Charlotte Department of Transportation

Memorandum

Subject: Rezoning Petition 08-088: Located on the southwest corner of south Boulevard and East Carson Boulevard (revised 6/20/08)

DATE: 03/24/08
DRAWN BY: RHP
CHECKED BY: RHP
SCALE: 1"=30'-0"
PROJECT #: 1007332
SHEET #:
Z-1-I

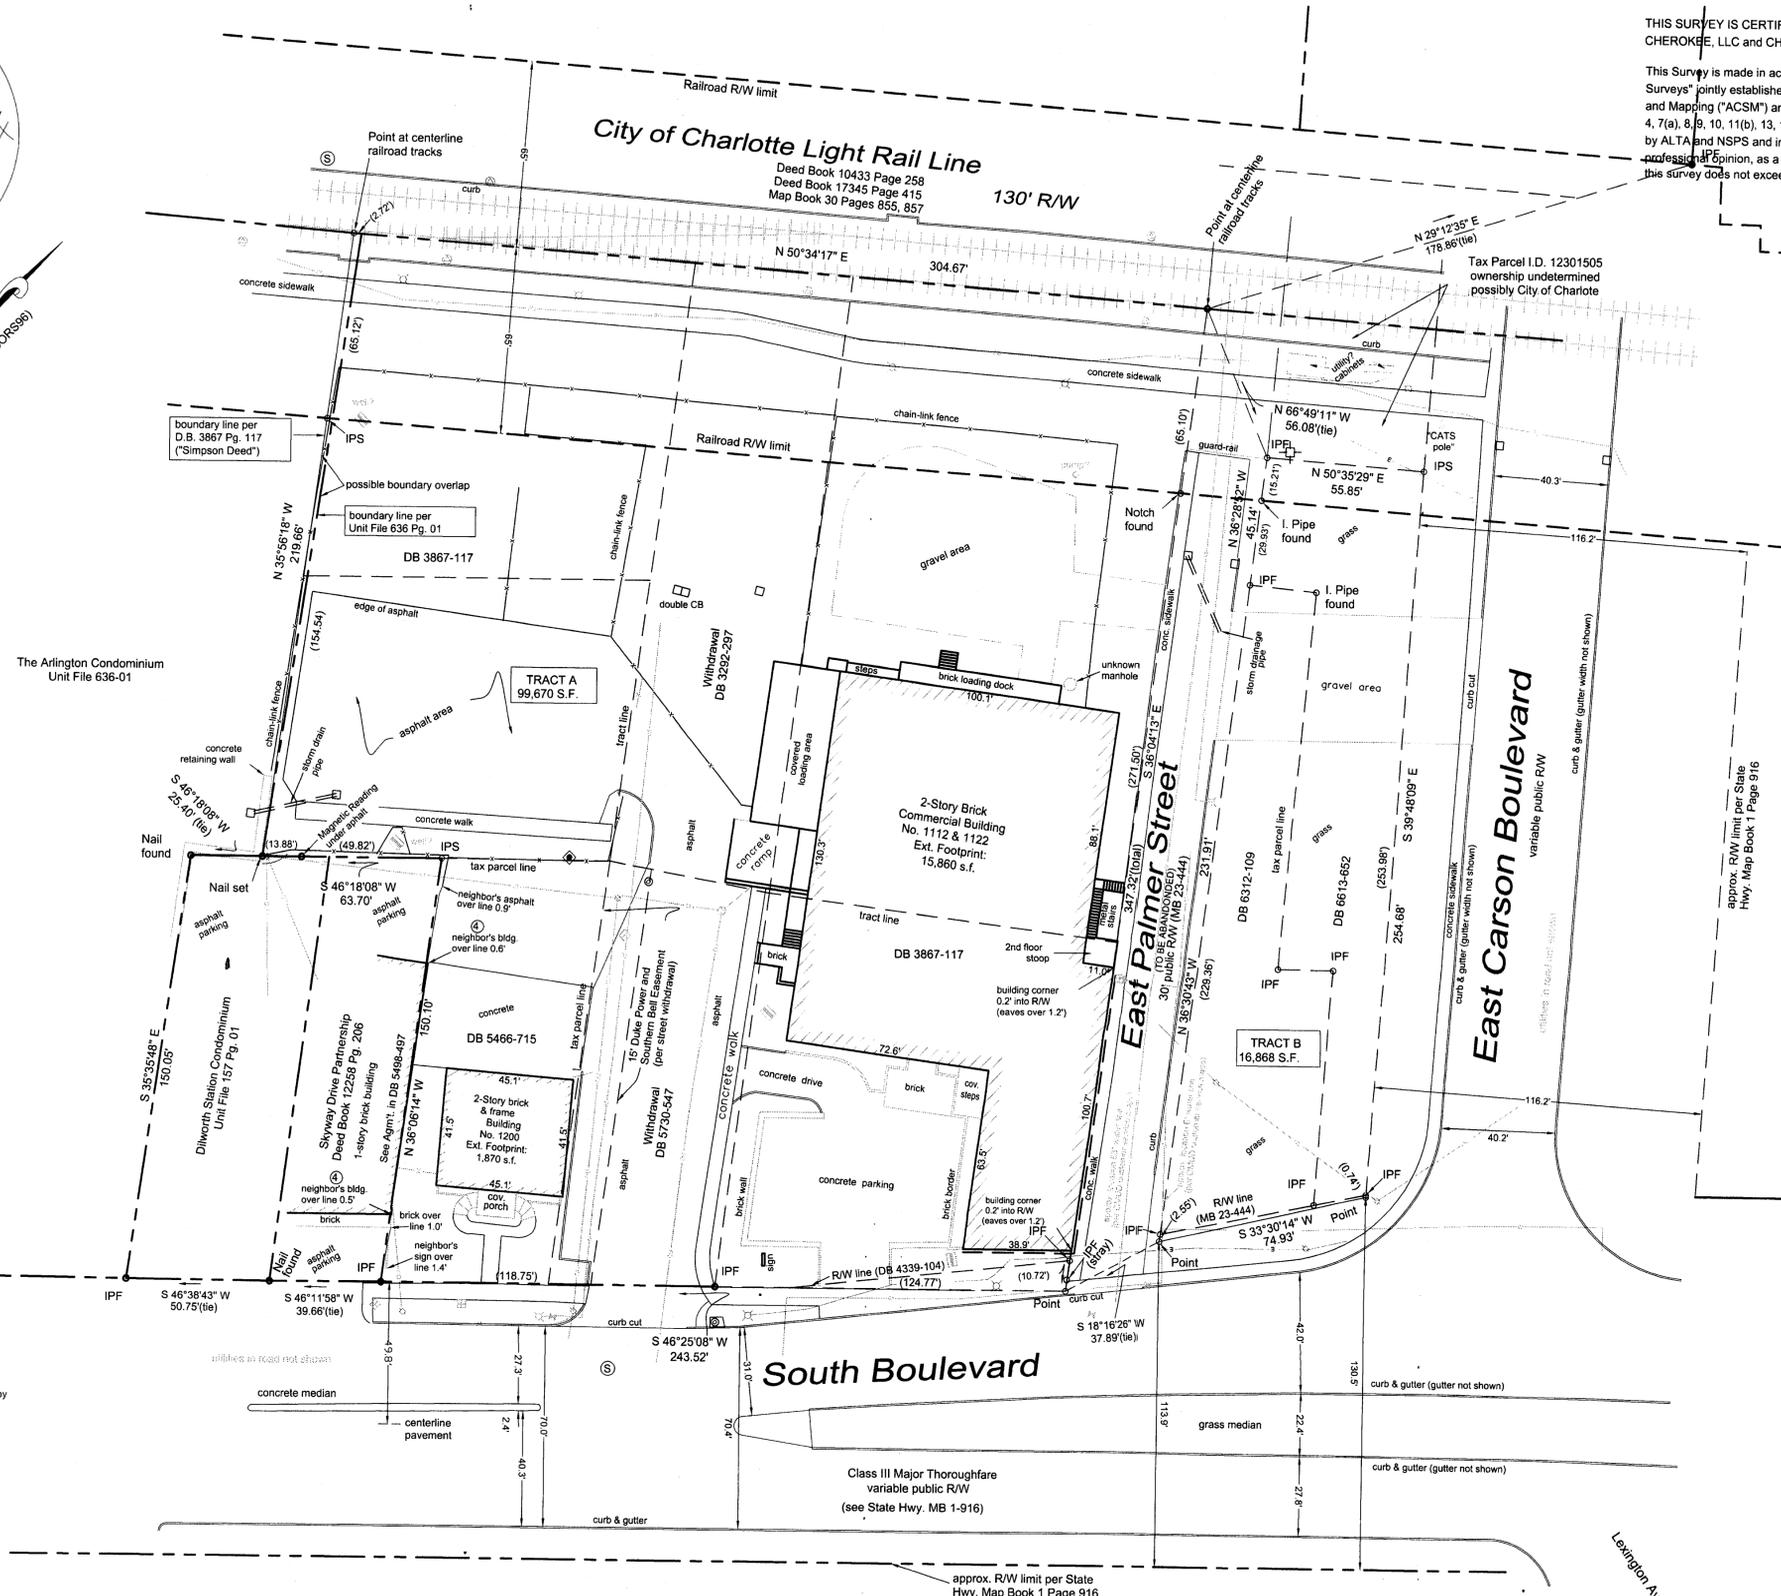
1. There is a proposed City project to realign East Carson Boulevard with Lexington Avenue and install traffic signals at the East Carson/Lexington/South Boulevard intersection. This project includes crosswalks and median refuge islands to facilitate pedestrian movements. The petitioner/developer has agreed to be responsible for the costs associated with these

roadway and intersection improvements including, but not limited to design, construction, pavement markings, and upgrade to steel pole/mast arms for the new traffic signal installation subject to the provisions of and entering into an Infrastructure Reimbursement Agreement (IRA) with the City. The IRA will be included as part of any Council decision on this rezoning petition. This needs to be more specifically noted on the plans.

2. The realignment of Carson Boulevard must meet the City's design standards and provide proper lane alignment for tie-ins to existing sections of Carson Boulevard and Lexington Avenue. Adjustments to Lexington Avenue east of South Boulevard may be necessary to meet minimum design standards/requirements. These items will be further reviewed during the subdivision plan review process. It will be necessary to obtain CDOT's approval of roadway and intersection design/construction plans prior to building/driveway permit plan submittals in order to determine final curblines, setbacks, and right-of-way limits. This needs to be noted on the site plan.

3. The proposed site plan requires the abandonment of portions of Palmer Street and Carson Boulevard. Although it is noted on the site plan that the petitioner will seek abandonment of portions of these streets at a later time through the abandonment process, the site plan does not show the existing rights-of-way. In particular, the location of the property line (future) shown on the Carson Boulevard frontage is not existing and is subject to approved construction plans and City Council's approval of the abandonment. This should be noted on the site plan.

4. We have previously commented on the need for the proposed full access driveway on East Carson Boulevard to directly align opposite the existing driveway on the north side of the street serving the Time Warner employee parking lot. The revised site plan still shows an offset location and notes that the location of the driveway will be coordinated with CDOT during the building/driveway permit process. The site plan and note need to be revised to indicate the location of the proposed driveway must align directly opposite the existing driveway.

5. The developer needs to provide additional right-of-way and/or setback to accommodate a 5-foot bicycle lane along South Boulevard. In areas adjacent to on-street parallel parking the bike lane must be 6 feet in width. Existing lane widths on South Boulevard must be maintained.
